Arun District Council
Arun Civic Centre
Maltravers Road
Littlehampton
West Sussex BN17 5LF
Planning & Building Control General Enquiries
Tel: (01903) 737756 Fax: (01903) 730442
Dx: 57406 Littlehampton
Minicom: 01903 732765
e-mail: planning@arun.gov.uk
website: www.arun.gov.uk/planning

Application No: A/41/22/DOC
Site Address: Land North of Water Lane Angmering BN16 4EU
Description of works: Approval of details reserved by condition imposed under ref A/40/18/OUT relating to Condition No 5 - design code masterplan.

Thank you for your internet representation made on 1st April 2022 which has been recorded as an objection with the comments as follows:

Public Transport / Dappers Lane Link
(Conditions 16 and 39)

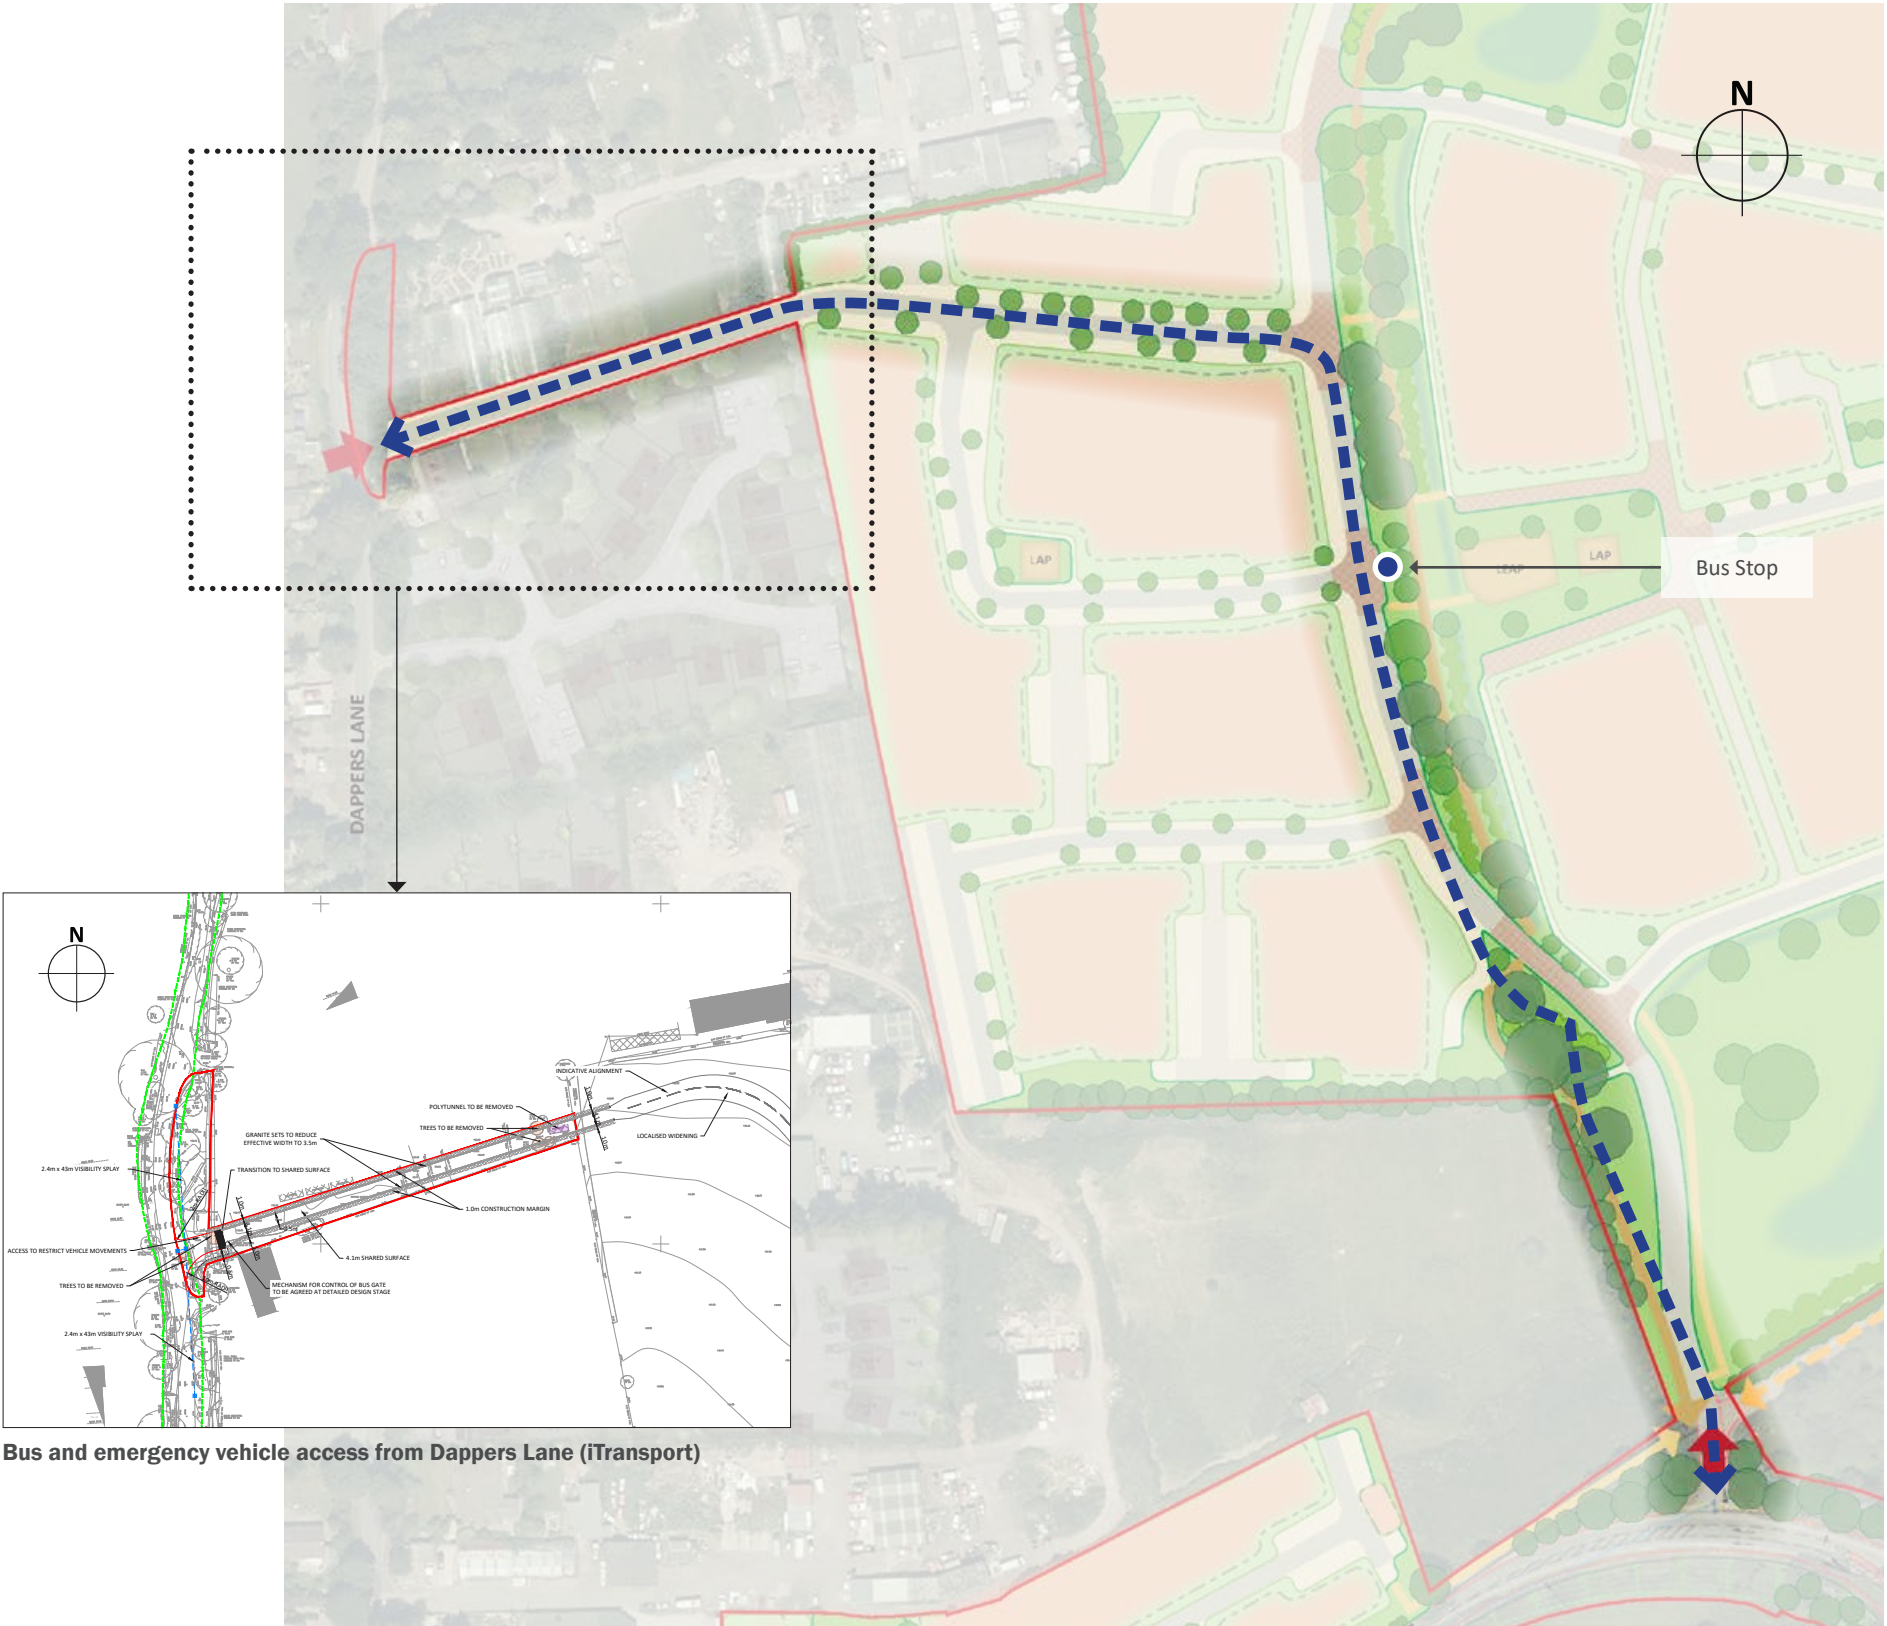
This new application A/41/22/DOC seeks approval of details reserved by conditions relating to the design plan mastercode. One of the plans submitted (Design Code-Rev A (Part 3), (Access, Movement and Parking) shows, under 3.2 Public Transport/Dappers Lane Link, two copies of the same plan for the limited access link road, each showing a physical barrier at the western end but still also showing the note "Mechanism for control of bus gate to be agreed at detailed design stage". There is no reference to an ANPR camera.

This could be interpreted as the developer having reverted to their original intention to install a mechanised barrier, but this has not been made clear, and there is no detail given as to the type of physical barrier or its mechanism.

It is essential that before any decision is made on this latest application the manner in which vehicle movement is to be restricted is clearly set out - that there will be a physical barrier, it's precise location and detail of the mechanism for its control
